From: Roger Frost [ferring-pc@btconnect.com]
Sent: 04 June 2008 08:50
To: Planning.Responses
Cc: Bryan McCansh
Subject: Re: Planning Consultation on: FG/69/08/

OBJECTION - FG/69/08 - 34 Elm Park

date. April 2008
scale. 1:50 and 1:100
DRAWING NUMBER 14408.1.

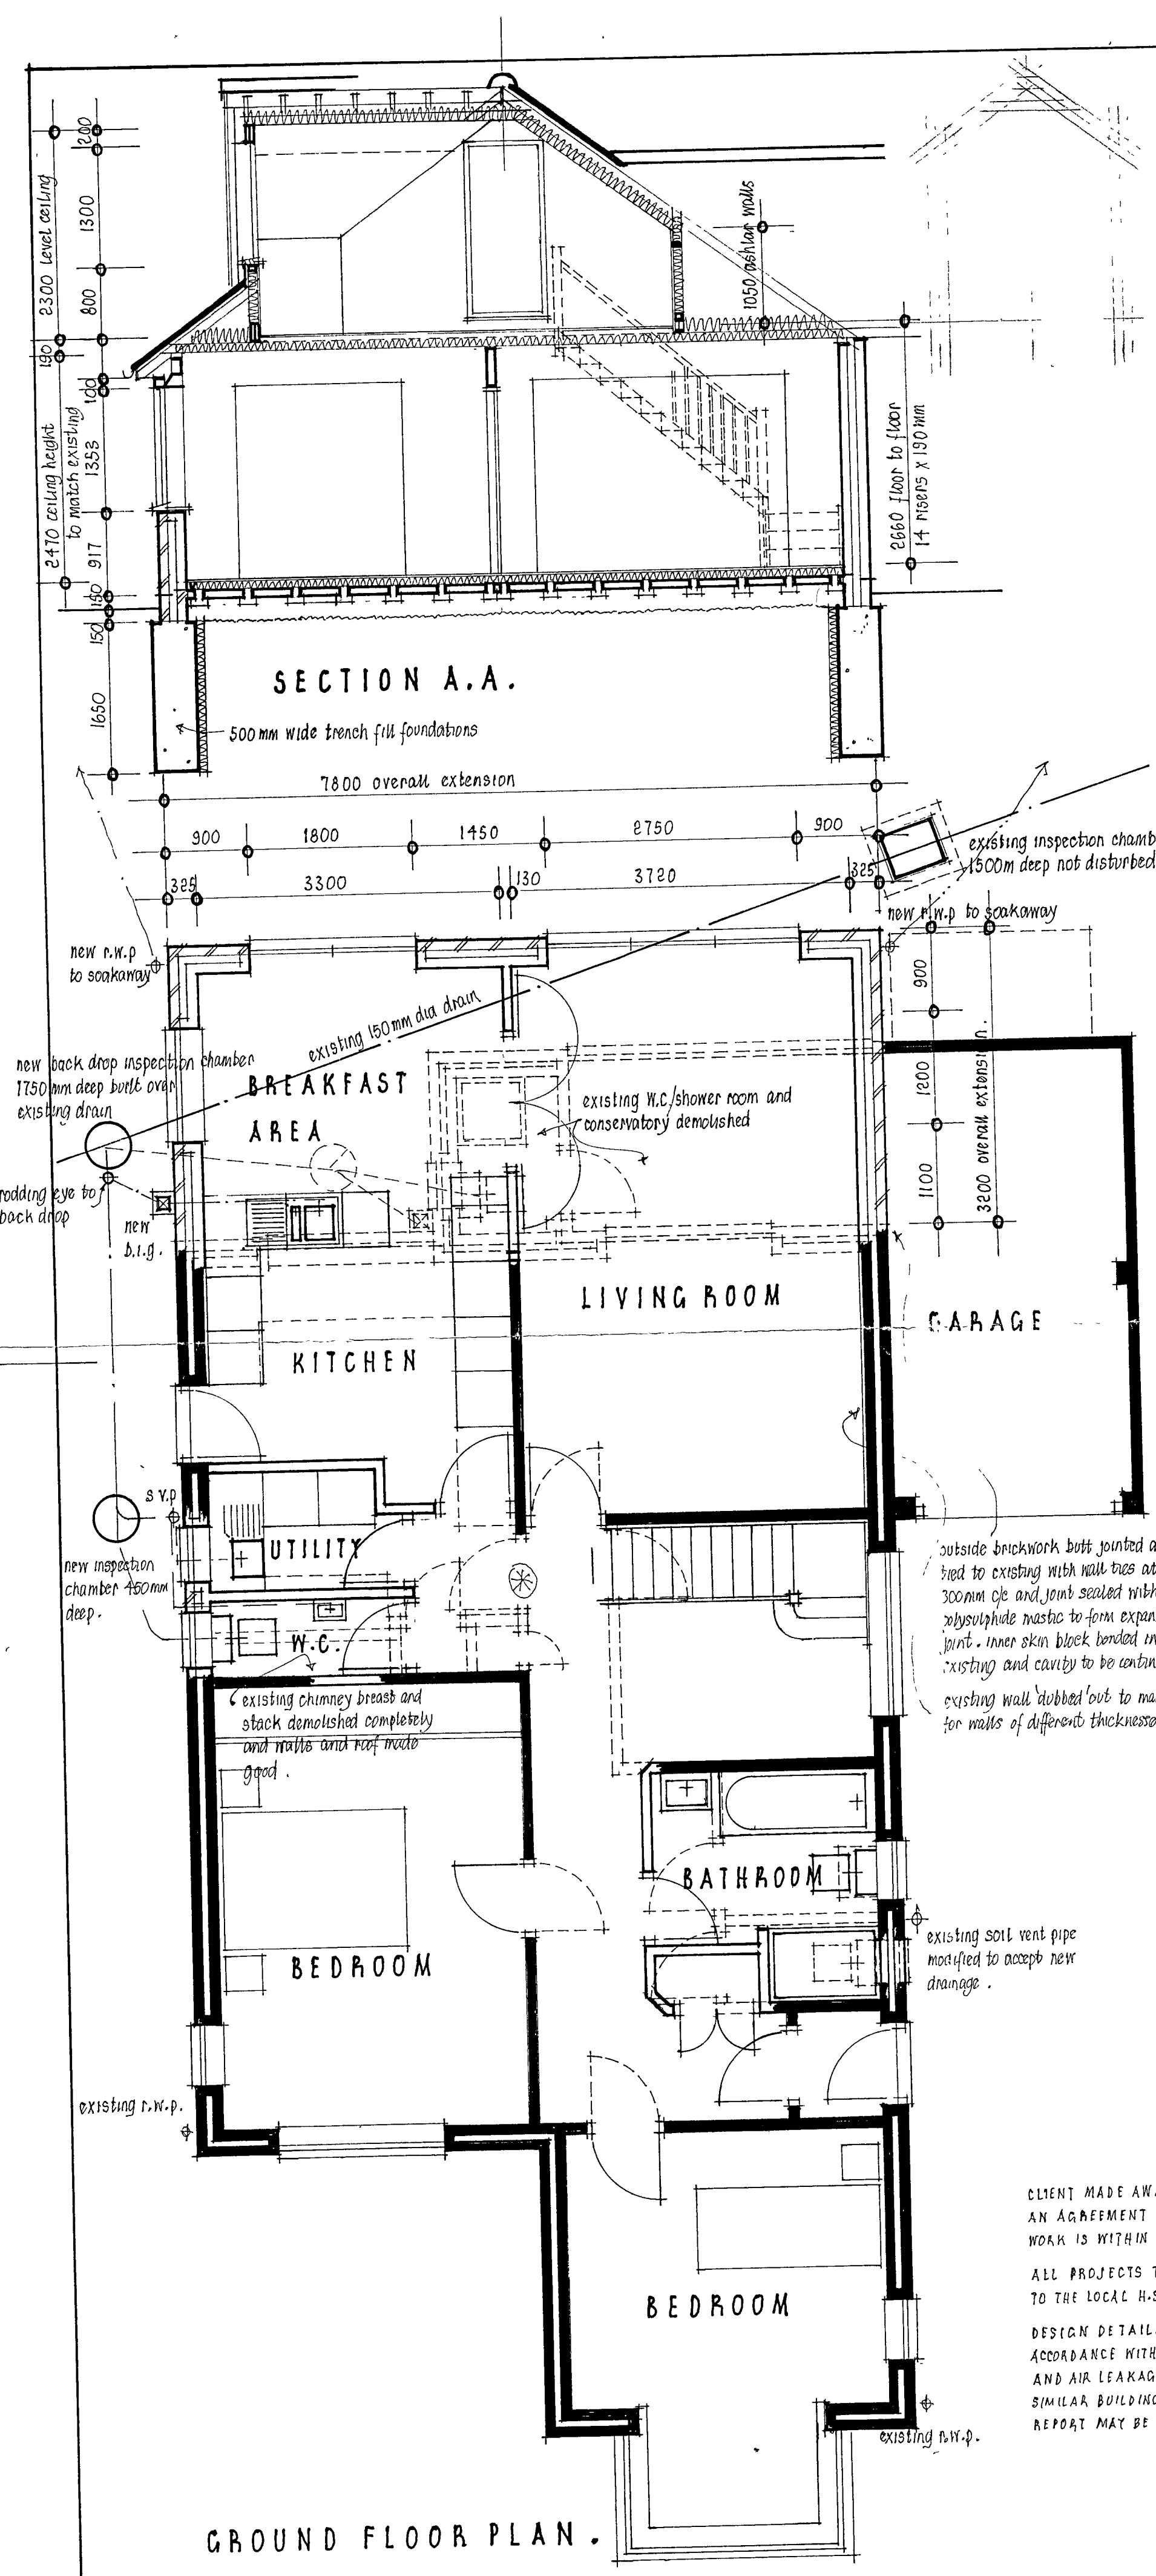
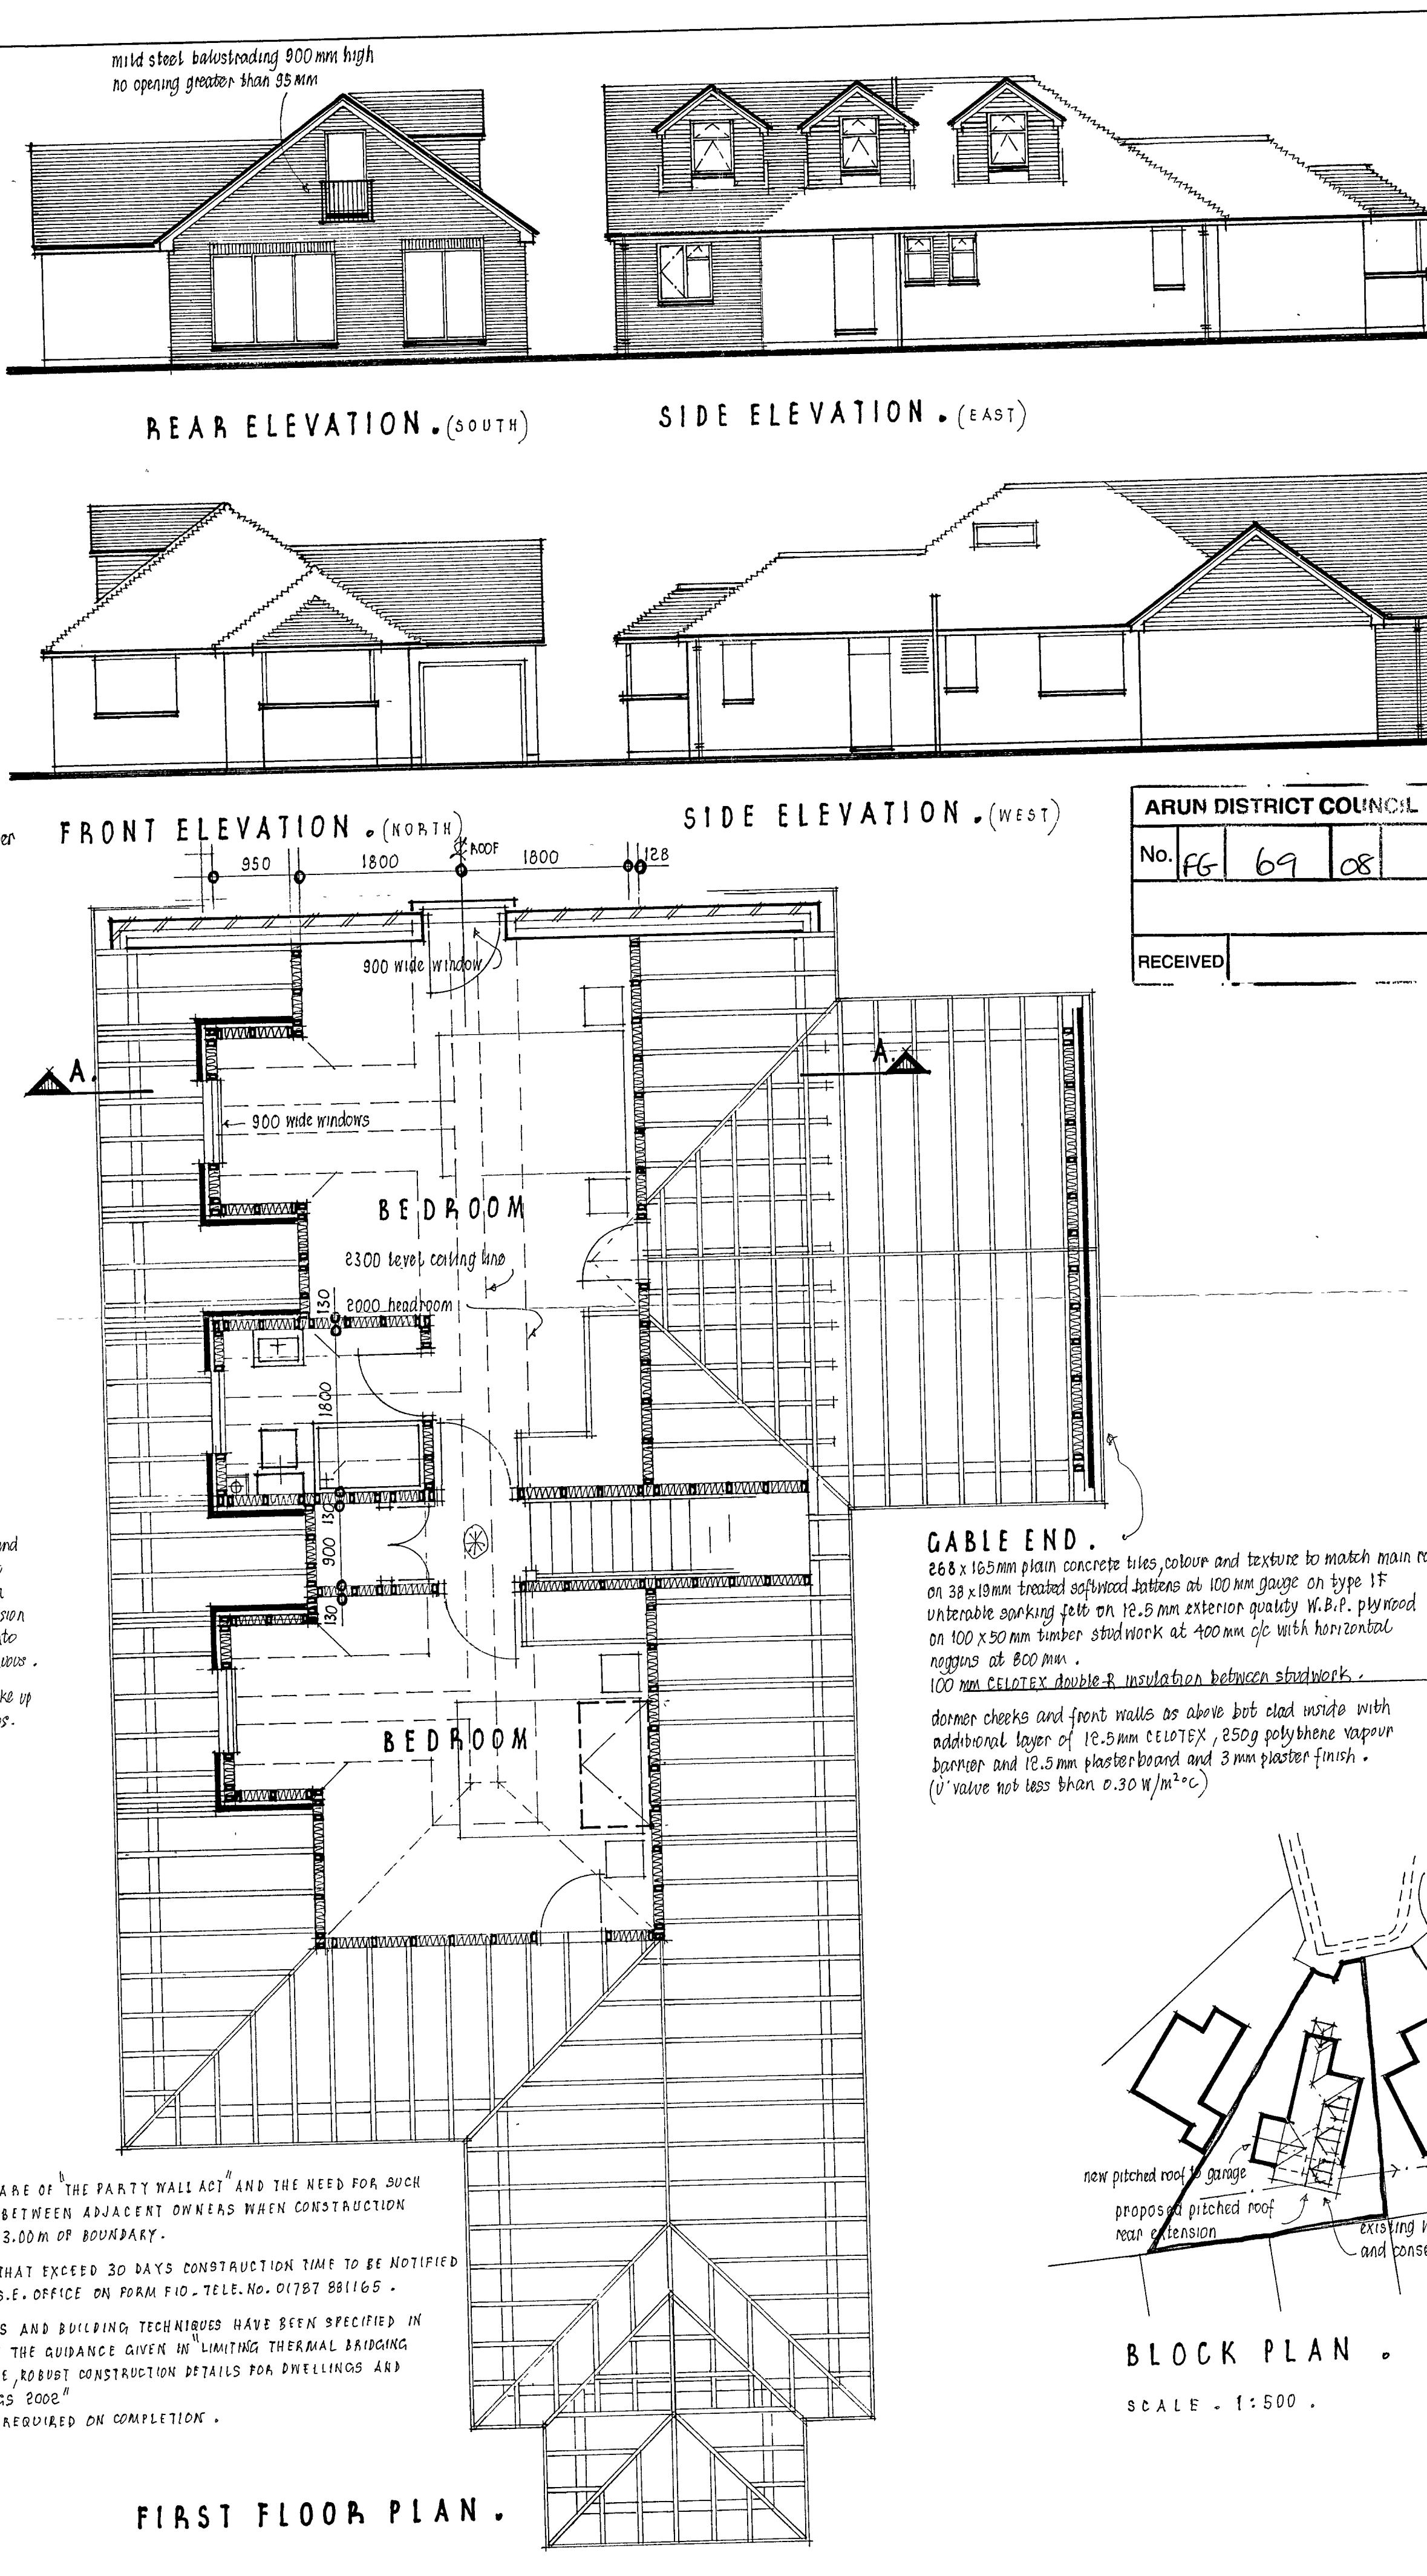
The Parish Council considers this proposal to be an undesirable , un-neighbourly and overbearing development in an area of low rise properties. which does not accord with the provisions of GEN 7 (ii).

The three dormer windows on the side elevation overlook the house and garden of the adjoining property which does not accord with the provisions of GEN 7 (iv).
The Parish Council wishes to raise strong objection to this development.
